# CITY OF ALBUQUERQUE

April 24, 2018

**RE: Lot 3 Block 3 Unit 22 SAD 228  
6328 Camino Alto NW  
Volcano Cliffs Subdivision  
Grading and Drainage Plan  
Engineers Stamp Date 4/16/18 (D10D003R3)**

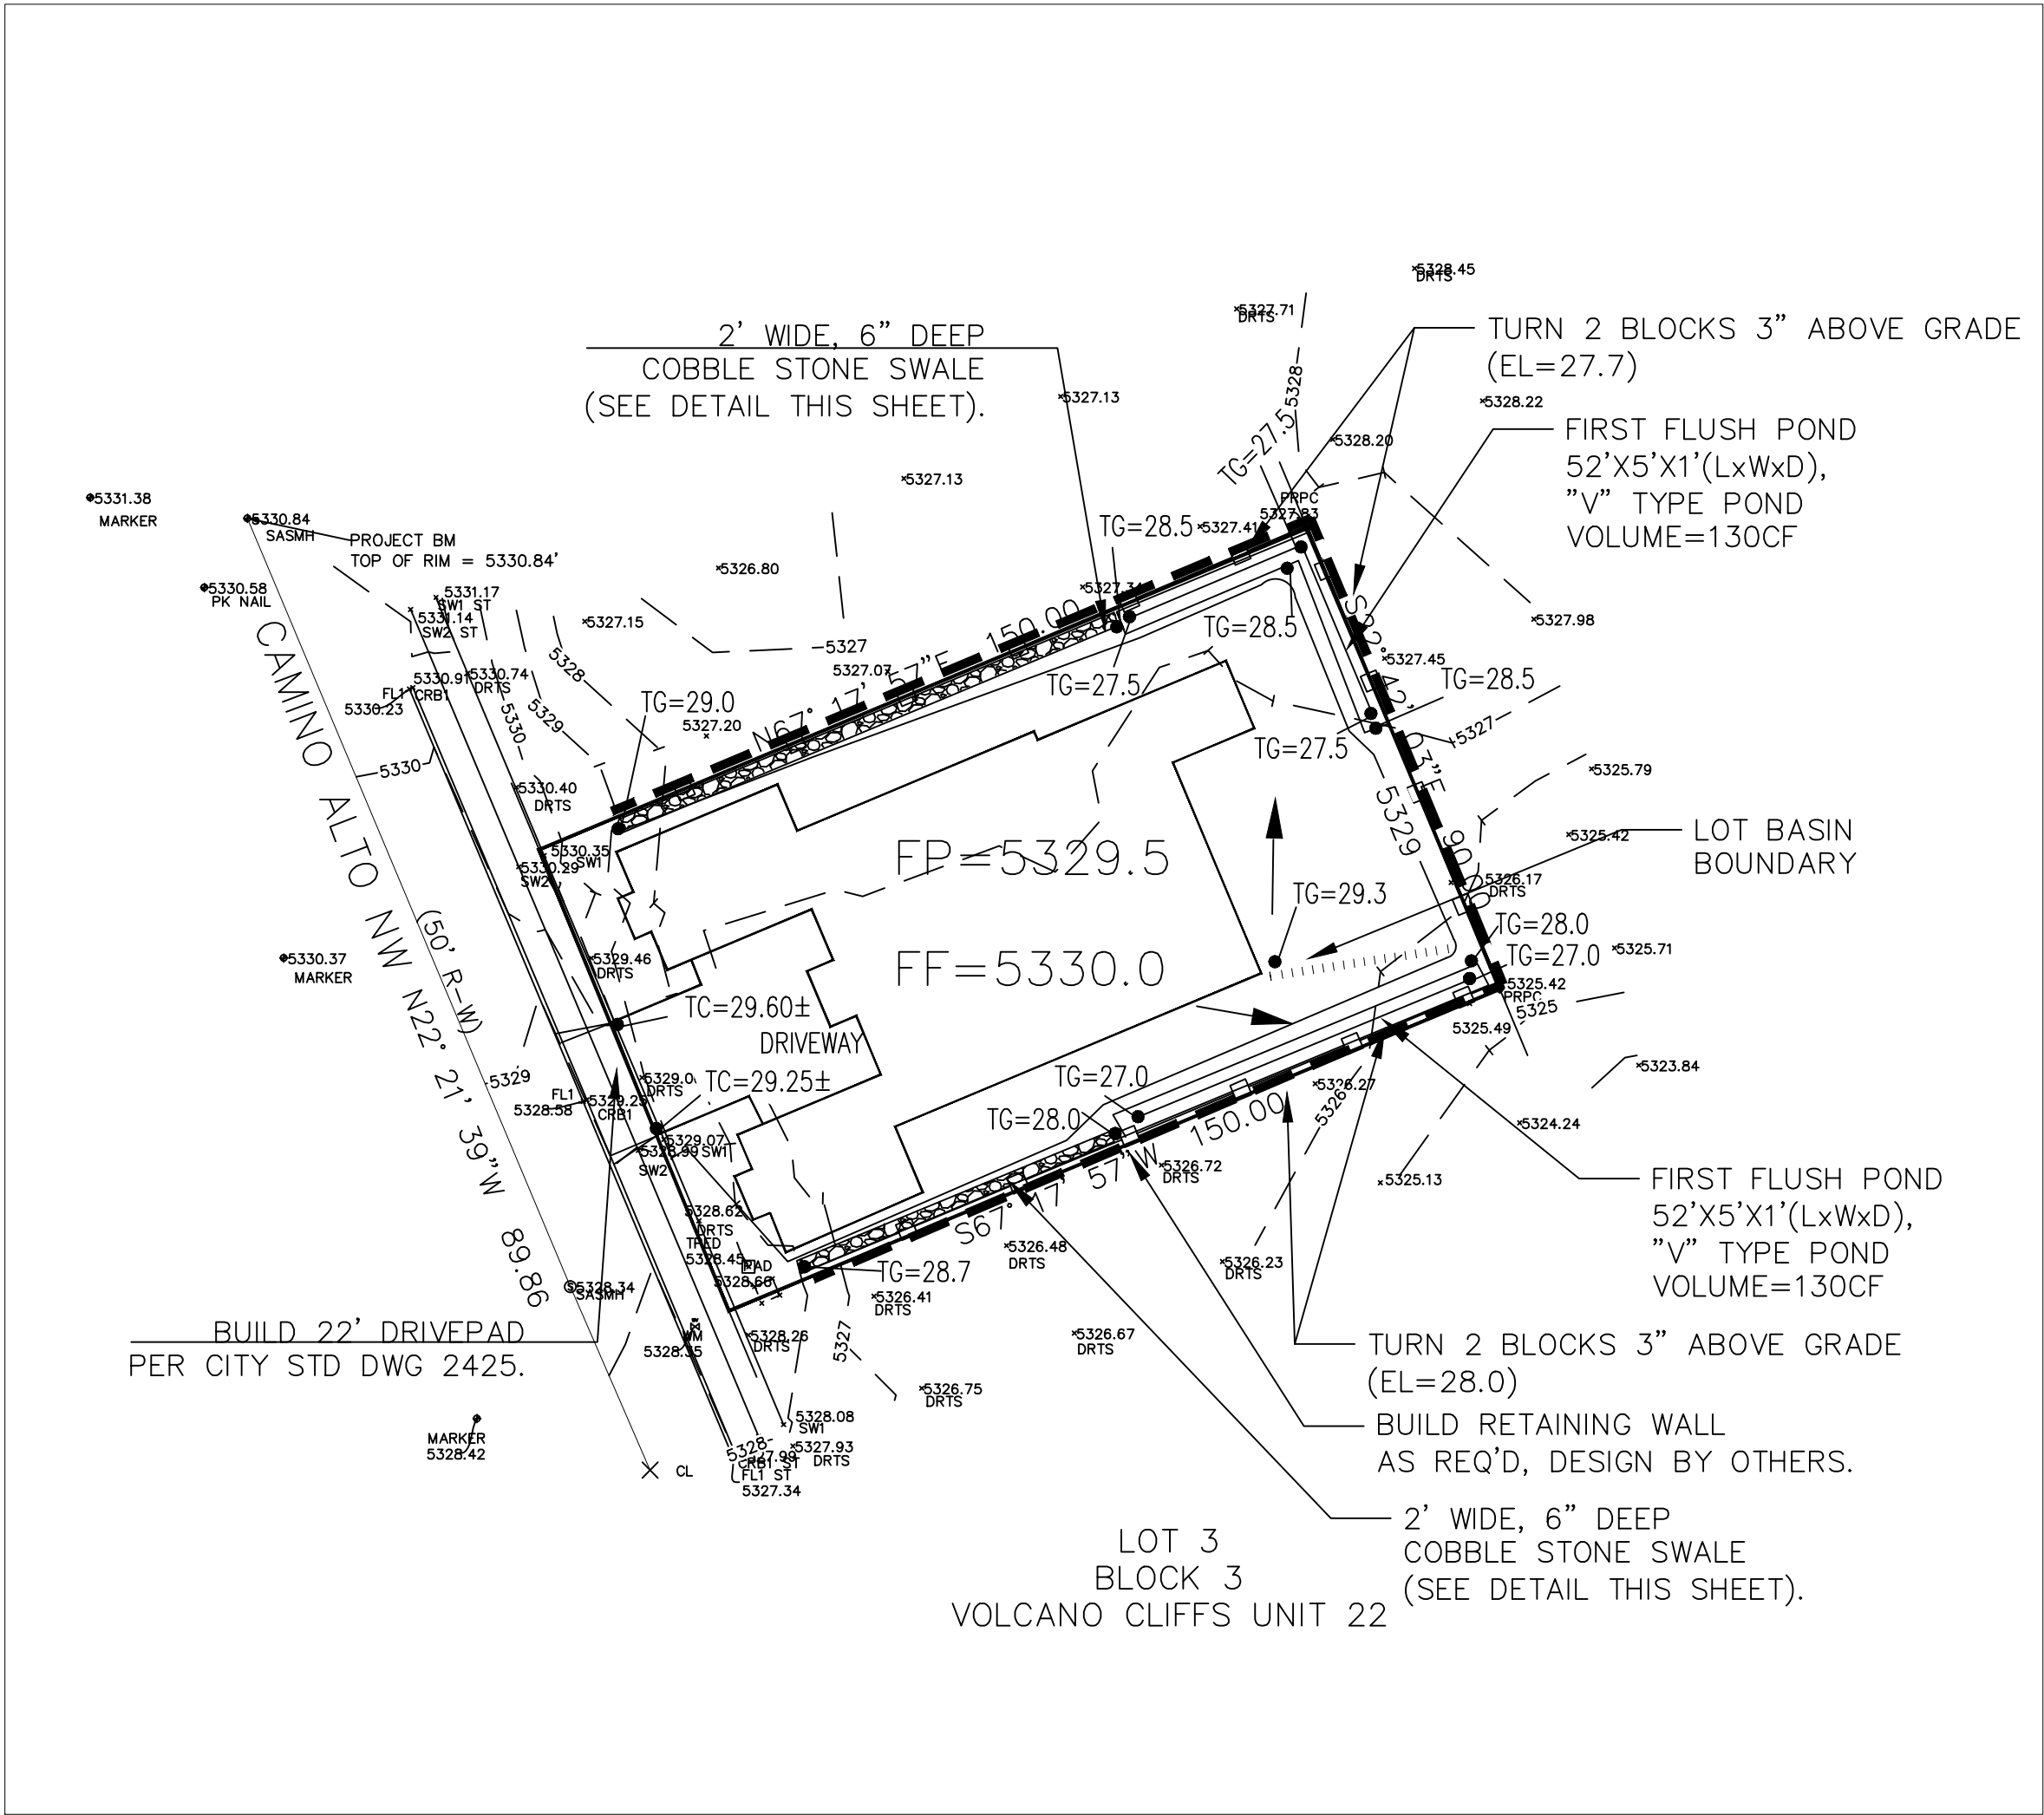
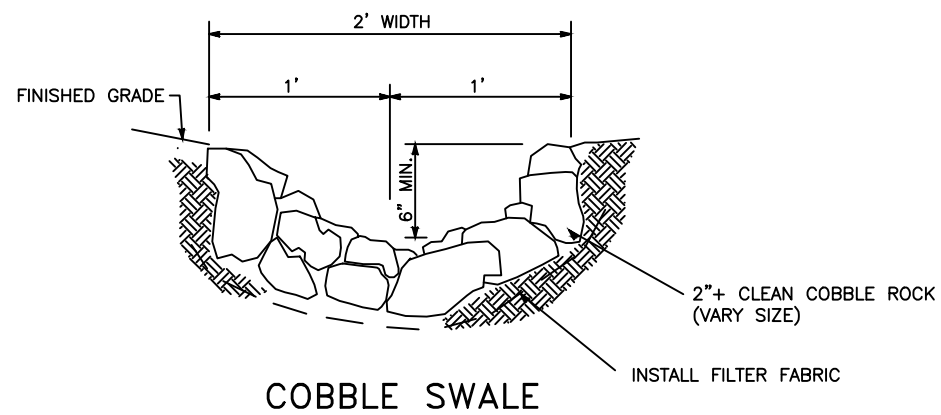
- Place turn blocks 3" above grade.
- Provide a note stating that a permit is required for the retaining wall and any future garden wall. This is the plan to follow dated 4/16/18 when applying for a perimeter block wall.
- Provide a cross section of the retaining walls showing location of wall pertaining to the lot lines. If encroaching into adjacent lots a written letter of approval from owners of the adjacent lots is required.
